July 16, 2021

**Project Name:** Super Star Car Wash - Falcon, CO  
**Project No.:** 020441-01-001 // PPR-21-008

This letter is in response to the letters dated March 11, 2021 – April 14, 2021.

DESIGN	DRAWN	CHKD
SWK	SWK	TOP
SCALE	H: 1" = 20' V: 1" = XXX'	
JOB No.	020441-01-001	
DATE :	02/09/2021	
SHEET	C3.0

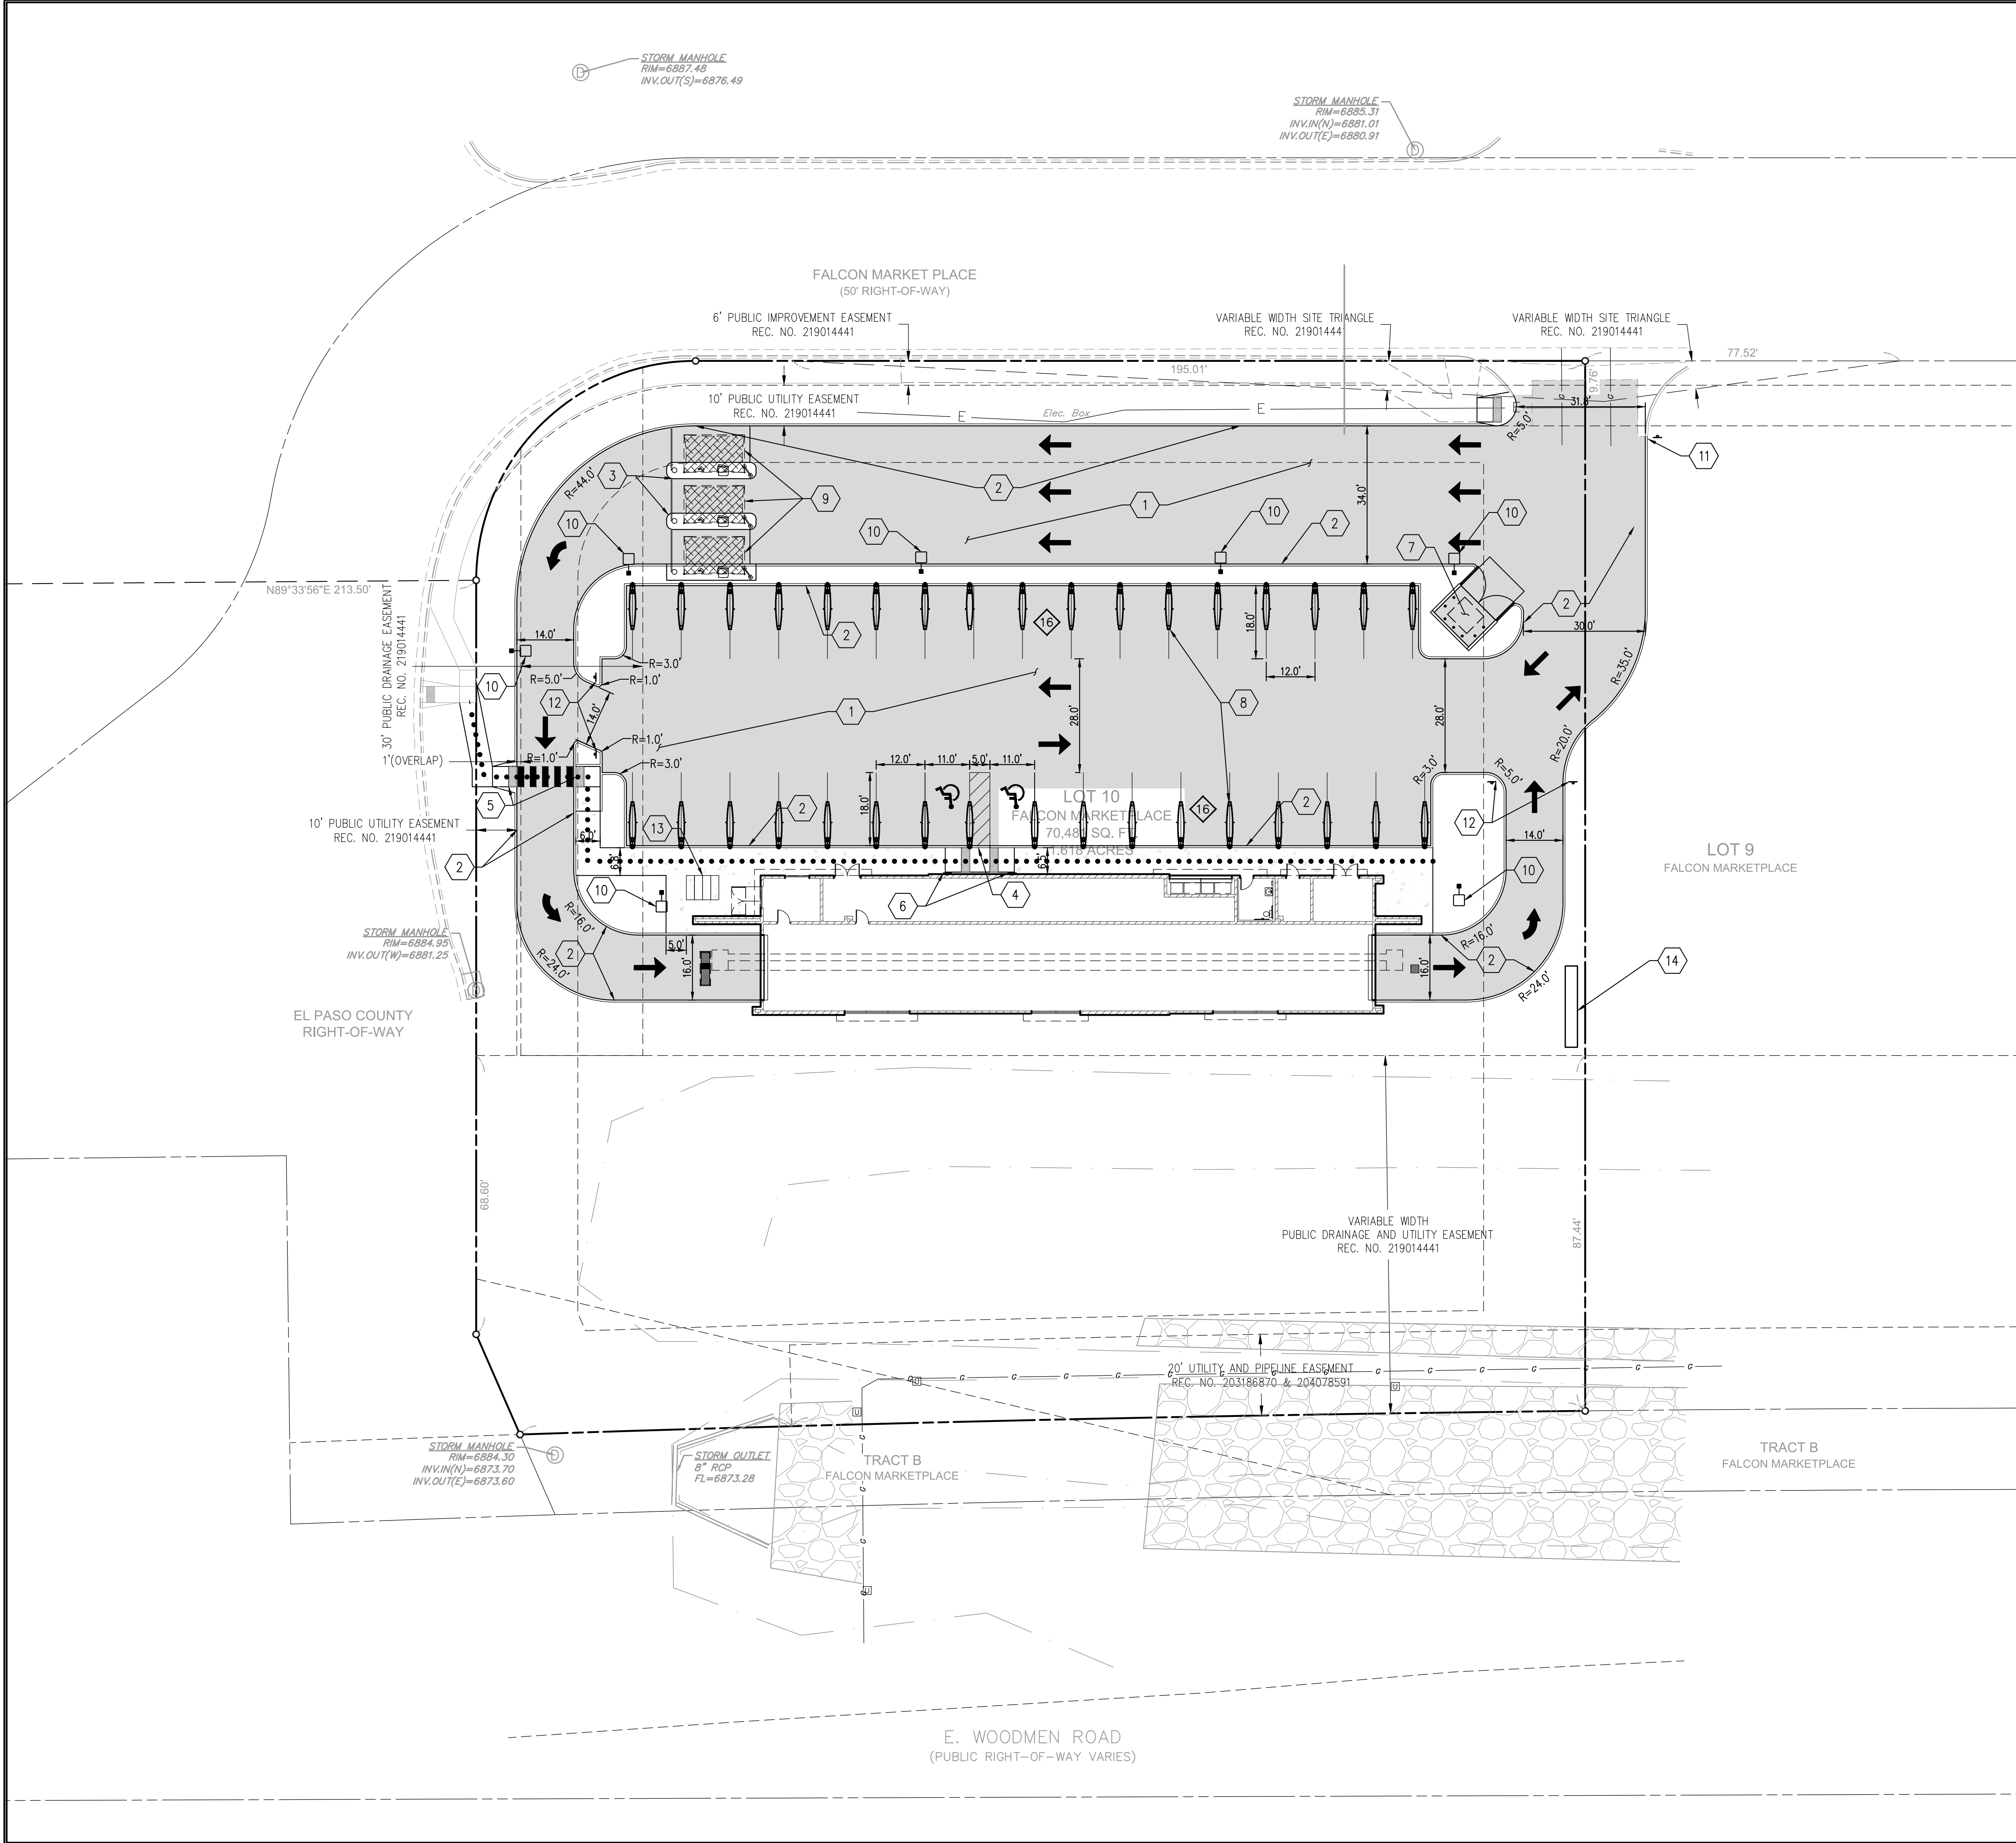
12. C3.0 – Please provide required ADA Note: Accessibility Notes

13. C3.0 – Please add and callout an ADA accessible route from parking spaces to building/throughout site. Also, one parking island is required per 15 or fewer spaces. Please add a trash enclosure detail to ensure compliance with LDC Ch. 6.2.2 refuse area screening requirements.

14. C3.0 - Per LDC Table 5-5 footnote 4, canopies must be setback from all property lines by 25 feet. Please show setbacks to ensure compliance with this requirement, or revise accordingly.

Also, your legend refers to architectural plans for a detail of these canopies, however I don't see a detail within this plan set, nor any of the renderings, elevations, or color board documents. I also don't see a detail for the vacuum stations. Please add to elevations or other drawings.

15. C3.0 - Please create an area on the bottom right corner of this site plan (by or incorporated into the title block) that is dedicated for the Planning Director's approval stamp.

16. C3.0 - Per Chapter 6 LDC parking standards: "the minimum number of bicycle parking spaces shall equal 5% of the total no. of required parking spaces. At least one bicycle parking space is required for all commercial sites.

17. C3.0 - Please label roadways and adjacent land uses and zoning designation

18. C3.0 - Please add a site data table including, but not limited to,; property address, parcel ID, zoning district, land use (proposed), property acreage, parking data table (required/provided), building height, setbacks, etc.  
Much of this information is described in the letter of intent, but please show within a site data table on the site plan.

20. C3.0 - Please show easements per approved recorded plat (snip showing easements below). Please also show any applicable easements referenced in the title commitment that was submitted (there are a few easements conveyed to MVEA and an easement for Diamond Shamrock gas pipeline company).

**Response: Note has been added to Sheet C3.0.**

**Response: ADA accessible route has been added to Sheet 3.0. Alternative Parking request has been submitted to reduce requirement.**

**Response: Per discussions with Sophie Kiepe on 5/3/21 the setback does not apply to the canopies being used. Details for both the canopies and vacuum stations have been added to sheet C8.1.**

**Response: 3"x1" block has been added for Planning Directors approval stamp.**

**Response: Bicycle parking has been added to the west side of the building.**

**Response: Adjacent roadways have been added.**

**Response: Site data table has been added to sheet C3.0.**
19. C3.0 - Please dimension ingress/egress width.  
**Response: Ingress/Egress width dimension has been added.**

**Response: Easements have been added to the plans.**
21. C6.0 – show HGL  
**Response: Hydraulic Grade Line has been added to all storm profiles.**
22. C8.0 - Latest version is dated 6/21/20

DESIGN SWK	DRAWN SWK	CHECKED TOP
SCALE	H: V:	
JOB No.	020441-01-001	
DATE :	02/05/2021	
SHEET La.01

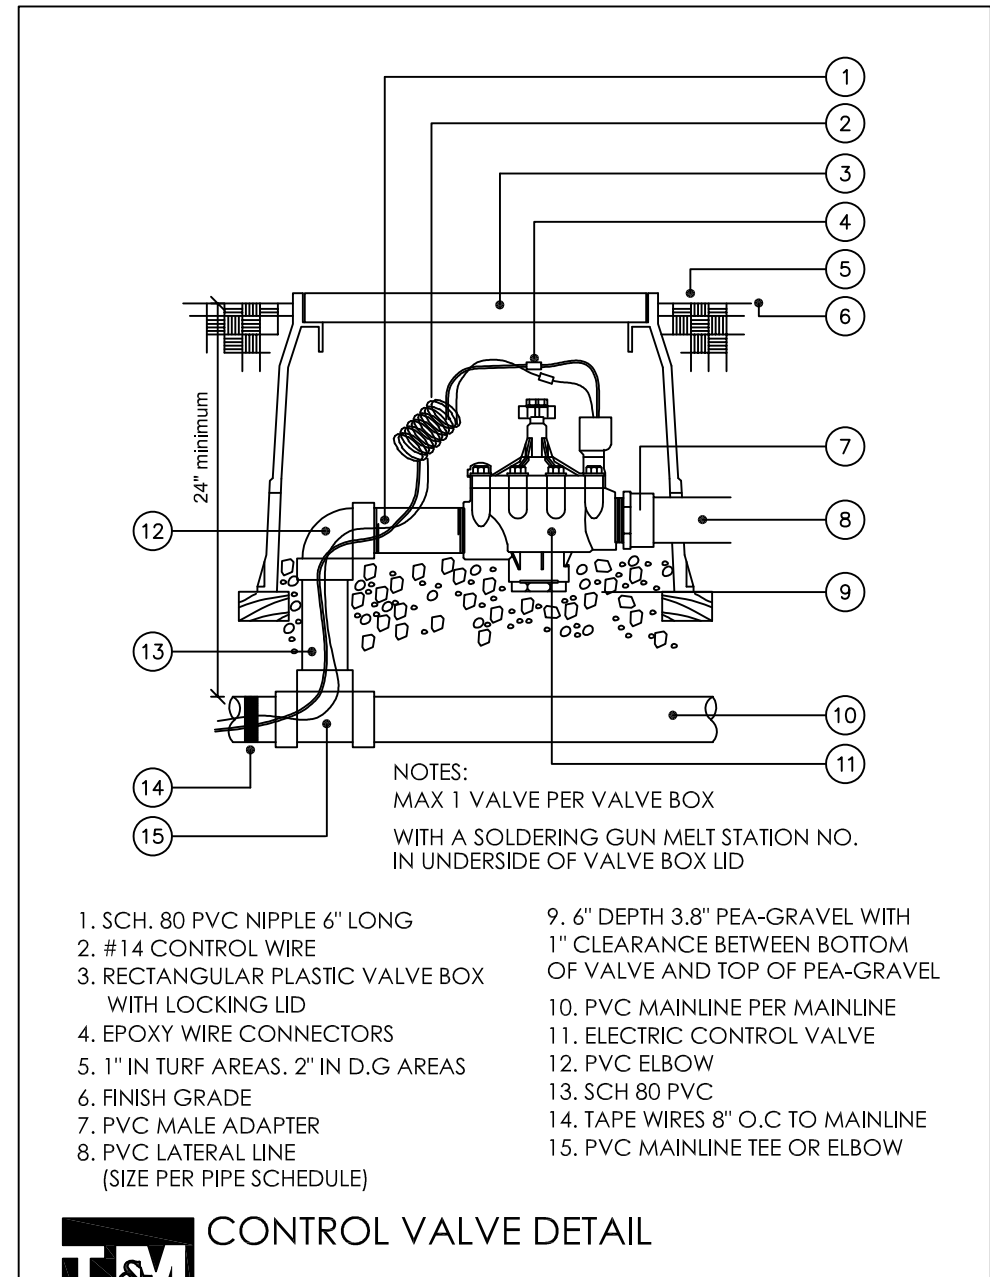
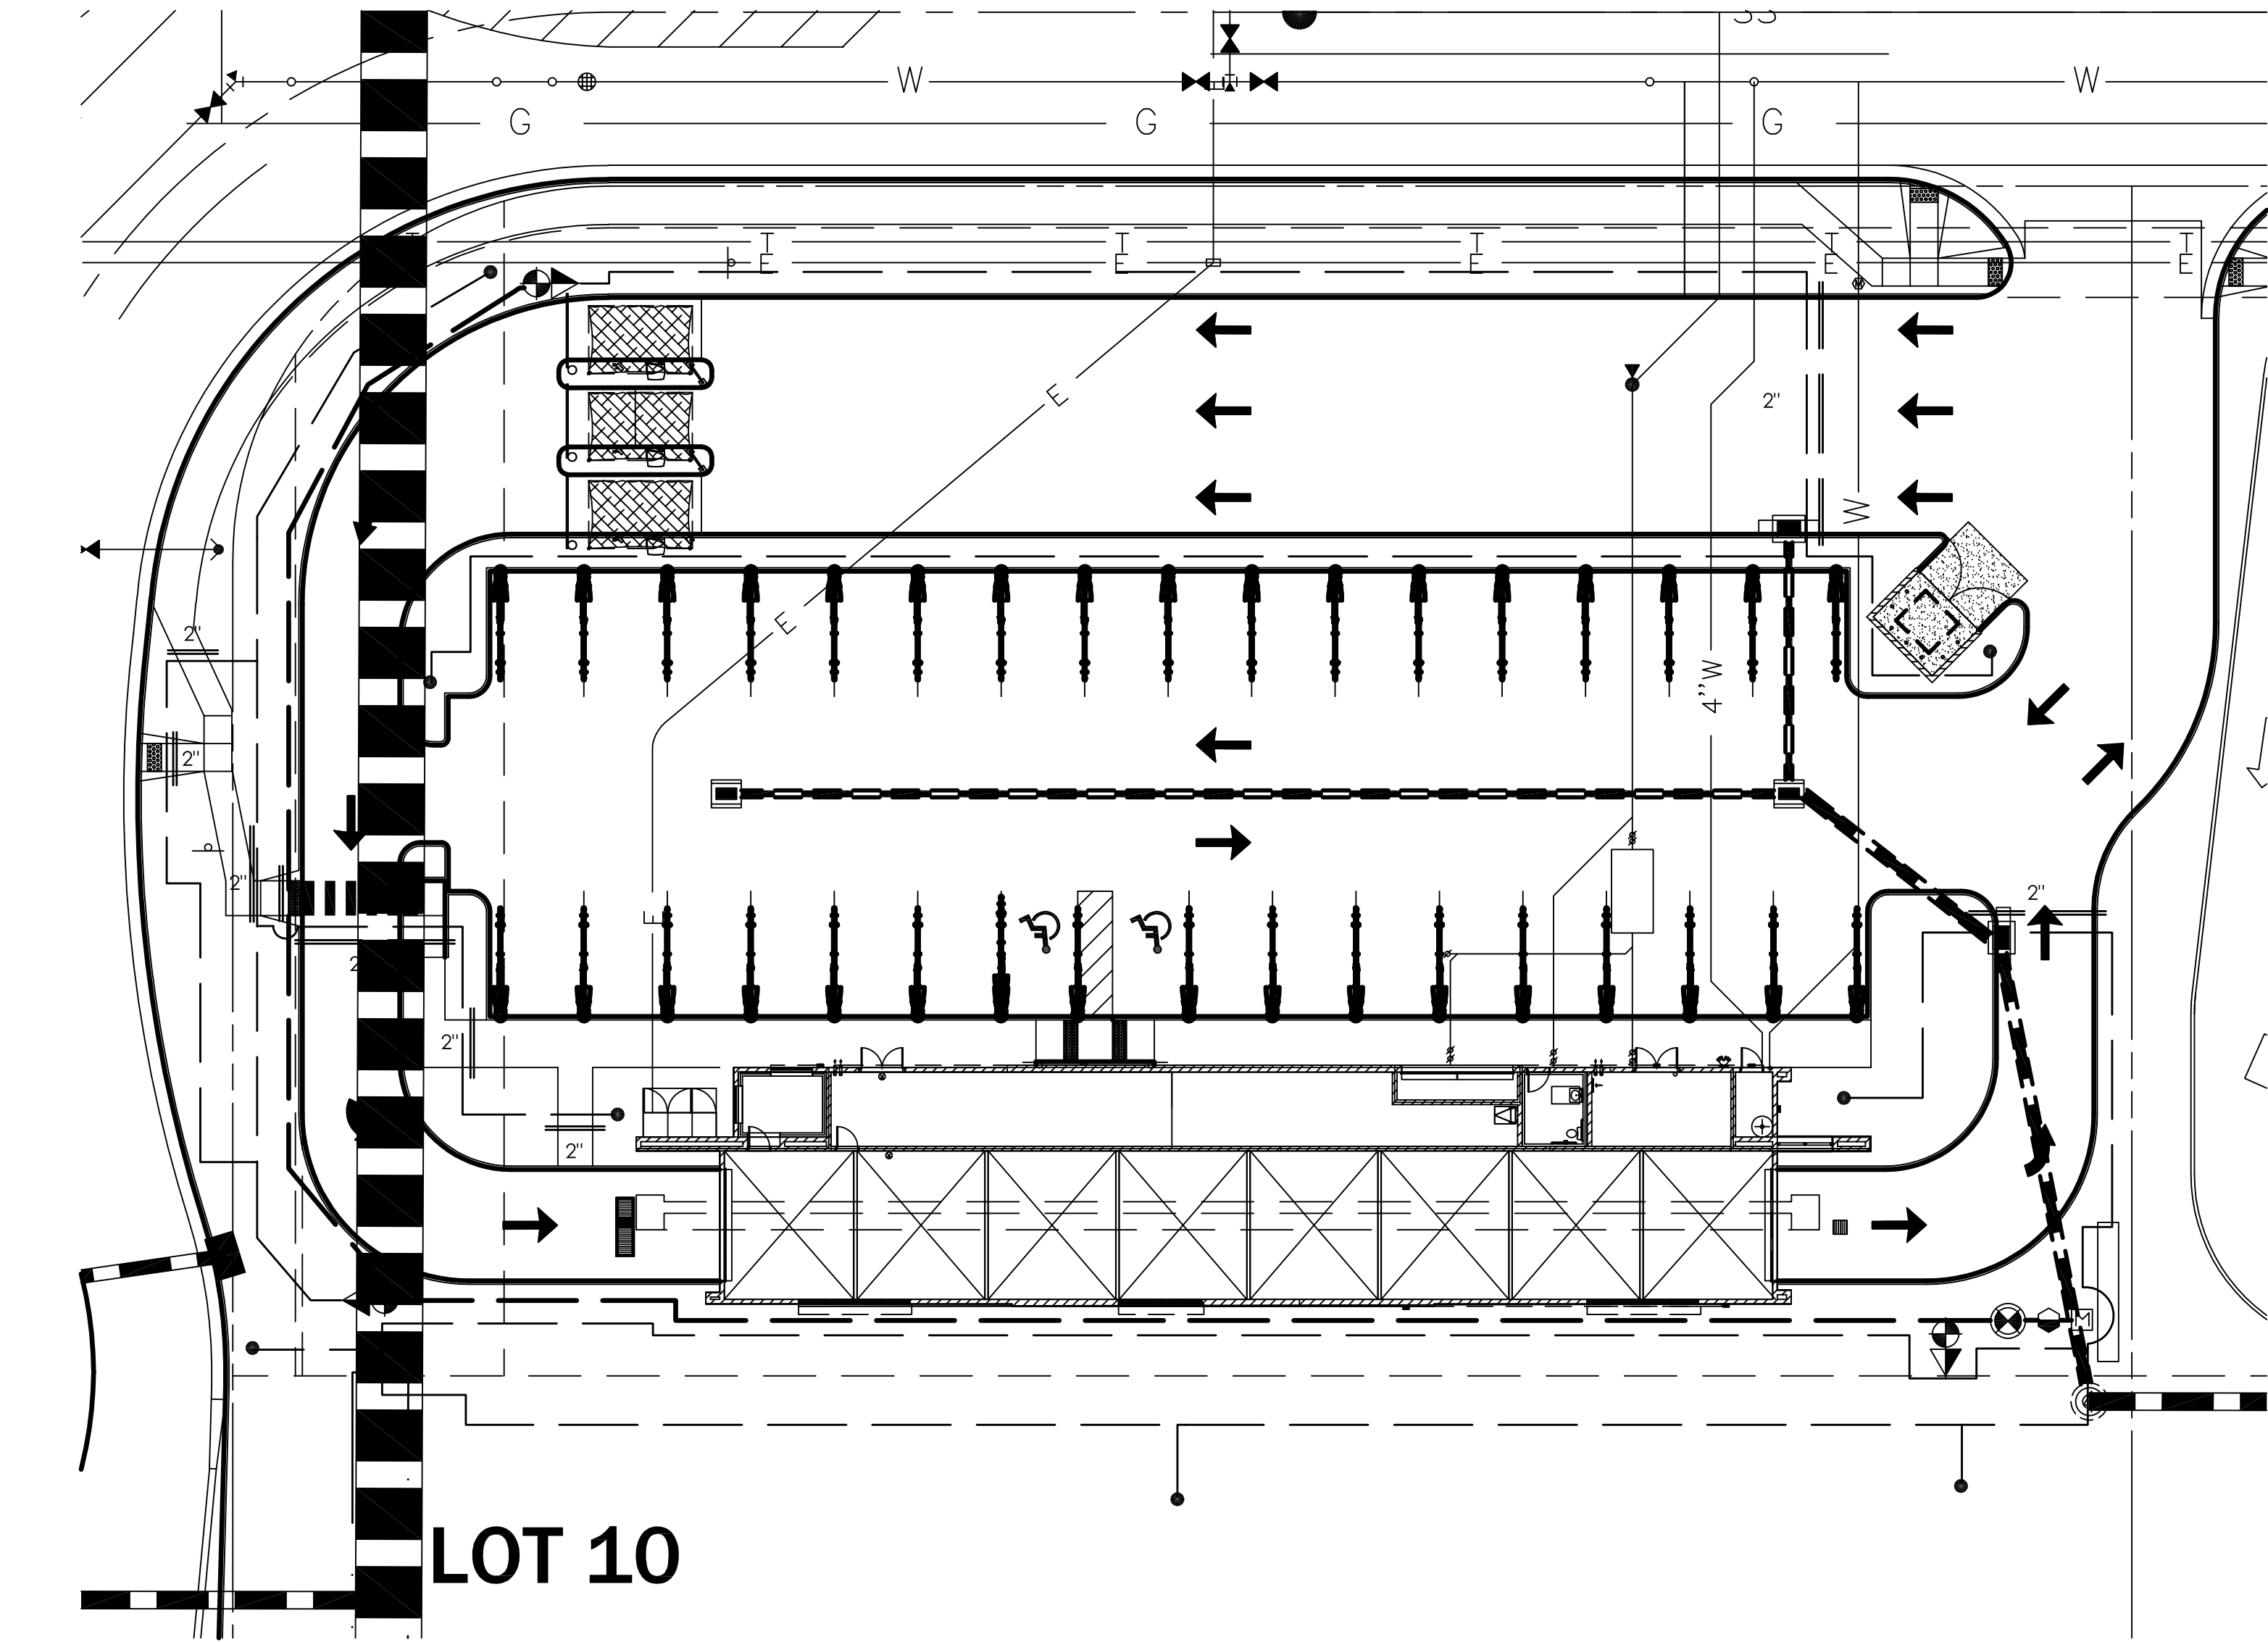
La.01 - Please clearly show the property line all around the property.

La.01 - Please show required ground cover information on plan and legend as required per LDC Ch. 6 landscape requirements and the master landscape plan for Falcon Marketplace (please refer to snips below of master landscape plan:

La.01 - LDC Ch. 6 internal landscaping and parking lot landscaping standards apply (are not included/satisfied in the master landscape plan for Falcon Marketplace).

La.01 - Please show depth of roadway landscaping areas and landscape buffers. Please ensure compliance/consistency with the approved roadway landscaping depth in the master landscape plan

La.01 - Please double-check consistency/compliance with the plant palette and designated tree types on the master landscape plan:

La.01 - Please also ensure that your plant caliper meets the minimum established for the applicable landscaping category LDC Ch. 6

**Response: Property lines have been clearly shown.**

**Response: Ground cover has been added to the legend and has been confirmed that it matches Falcon Marketplace ground covers.**

**Response: 1. Understood. 2. With the vacuum risers islands are not possible with this development. 3. More than 5% landscape has been provided within the parking lot area. 4. Parking lot is screened by shrubs and building from adjacent property to the south.**

**Response: Dimension has been added showing a 10' landscape buffer. And matches the Falcon marketplace masterplan.**

**Response: All trees used are on the Falcon Marketplace masterplan, and has been confirmed.**

**Response: Trees calipers have been changed to 3" to assure trees are meeting caliper requirements. As the master plan is being finalized this increase in caliper will insure our project (if it stands alone) meets caliper requirements.**
